Jeff Levine, AICP
Director, Planning & Urban Development Department

July 30, 2015

Project Name: **Lot #5 Industrial Way – new office building**
Project ID: #2015-085
Address: 81 Industrial Way CBL: 326 C005001
Applicant: Deerfield 91 Industrial LLC
Planner: Jean Fraser

### PLANT LIST

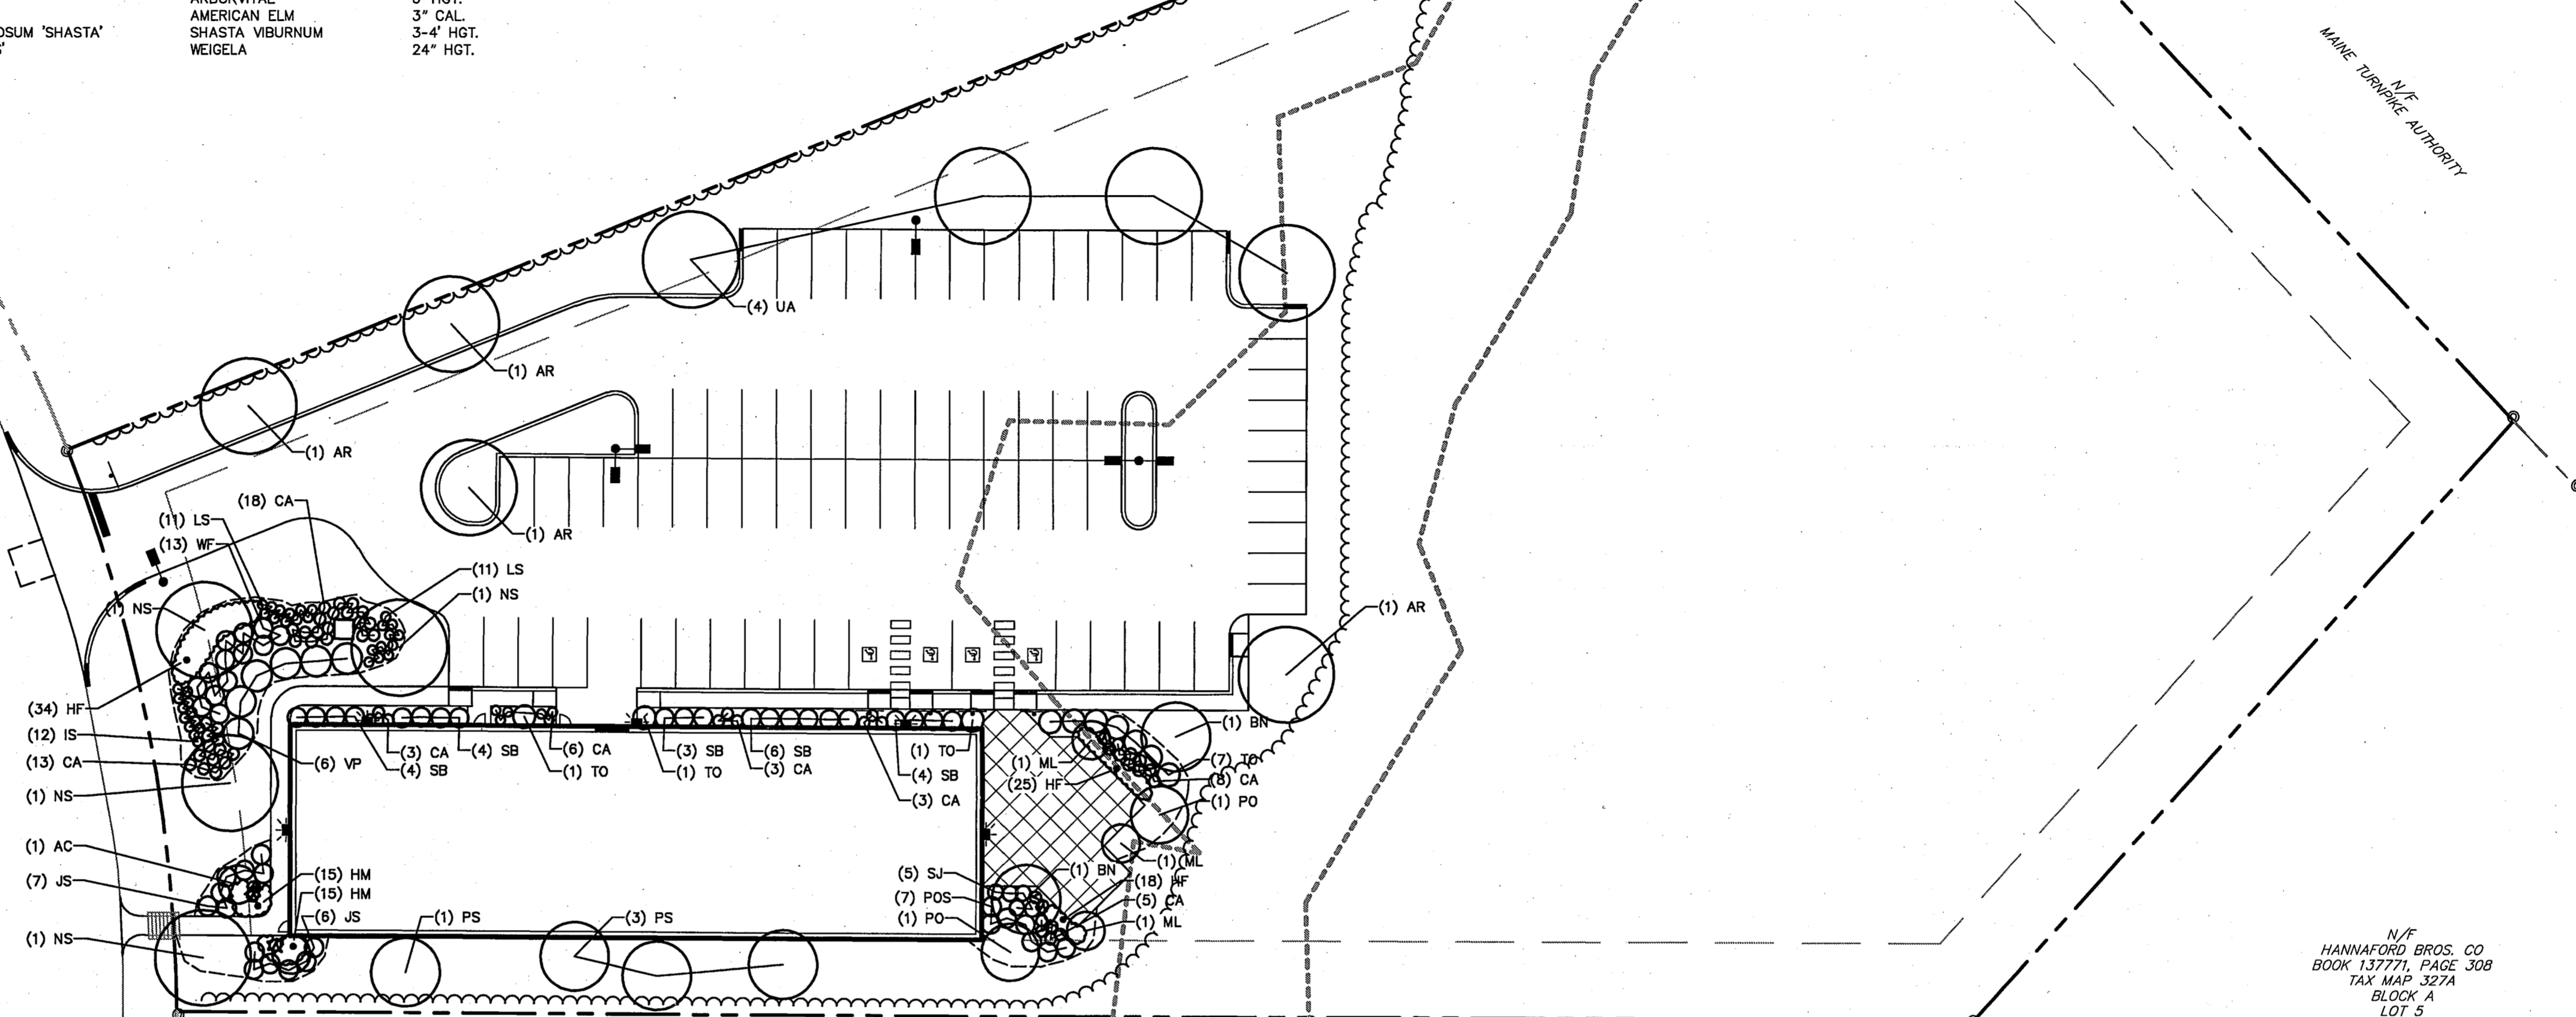
- i. That the applicant shall revise the Landscape Plan for review and approval by the City Arborist and Planning Authority prior to the issuance of a building permit, in order to address the Site Plan Ordinance landscape preservation and parking lot landscaping standards; and
